Report following a request for further information, negotiations or consultation

REF NO: R/197/20/OUT

LOCATION: Croft Works
52 Mill Lane
Rustington

PROPOSAL: Outline application with some matters reserved for the demolition of existing dilapidated storage buildings & erection of 2 No. detached 3-bedroom chalet bungalows with associated car barns, gardens, car parking & landscaping (resubmission following R/117/20/OUT).

View from Mill Lane along access driveway

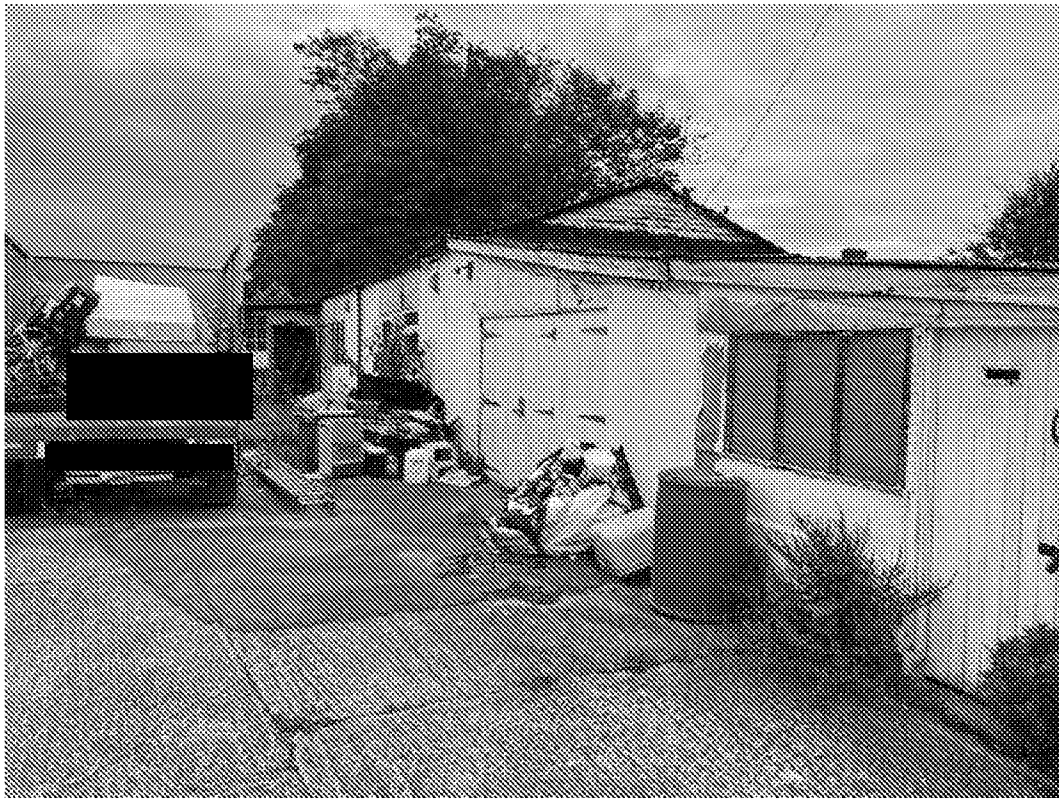
The agent has subsequently visited the site and measured the width of the access at several points along the access road and taken photographs of where the measurements are taken from. A revised drawing showing these dimensions has been received and the case officer has visited the site to verify the measurements given.

SITE PLAN 1:250

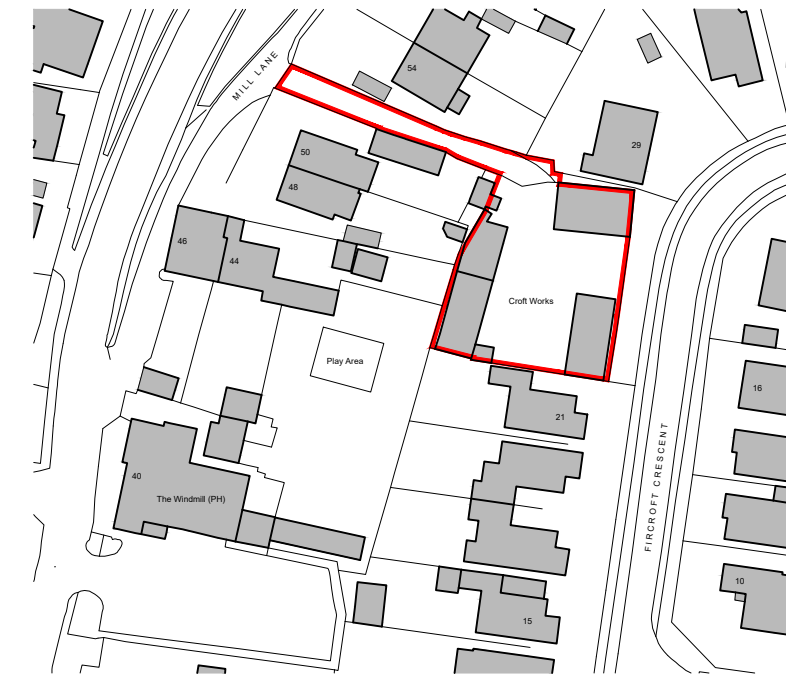
This application was deferred from the DC Committee meeting on 06-01-2021 to check that the width of the access road complies with building regulations for access by fire service vehicles. This is set out in Approved Document - B (AD-B) Volume 1 2019 section 13 Table 13.1 on page 98. It is expected that vehicles will travel in a straight line, not need to make a turn whilst passing through and there should be 3.7 metres between curbs.

Following the case officer site inspection it was found that the width of the entrance point is very close to the previously noted 4.65m at around 4.4- 4.5m. There is a pinch point at around the centre of the access driveway where this reduces to 3.3m wide. At the end of the driveway the dimension measures 3.8m which is slightly less than the 4.1m on the title plan.

Based on the measurements determined by the case officer it would appear that the access way would not be capable of complying with the above stated Building Regulations.

'County Water and Access have viewed the plan and agent's e-mail and confirm the current intentions do not meet with the requirements of Approved Document - B Volume 1: 2019 edition B5 section 13 for Fire Appliance access. The minimum access width for a fire appliance is 3.7 metres between curbs and 3.1 metres through a gateway in a straight line, so there is adequate access width, there is also a need for suitable space to turn and make an exit, which may also be possible.

However for houses fully sprinklered in accordance with British Standard (BS) 9251: 2014 or BS EN 12845, BS 9991:2015 para 50.1.2 does allow the distance between the fire appliance and any point within all houses to be up to 90 metres. The distance from the main road to the furthest point is

If access to the properties is not suitable for a fire appliance there is no reason to have a fire hydrant along the access driveway. Fire hydrants provide water to the fire appliance not the scene of the fire; there is an existing fire hydrant within 30 metres of the access point. The preference would be to gain access to the properties, if this cannot be achieved each property will need to be fully sprinklered.'

The agent has advised that appropriate Building Regulations will be met by way of the provision of sprinklers and/or a fire hydrant. This can be secured by way of a condition.

The Council's Building Control Department has advised that a suppression system, such as sprinklers would be acceptable.

The recommendation has been amended by the inclusion of the updated block plan showing true dimensions of the access road (amending the plans condition 2) to refer to the later amendment and the inclusion of an additional condition (number 19) requiring that prior to occupation details of a sprinkler system be provided and agreed with the Local Planning Authority.
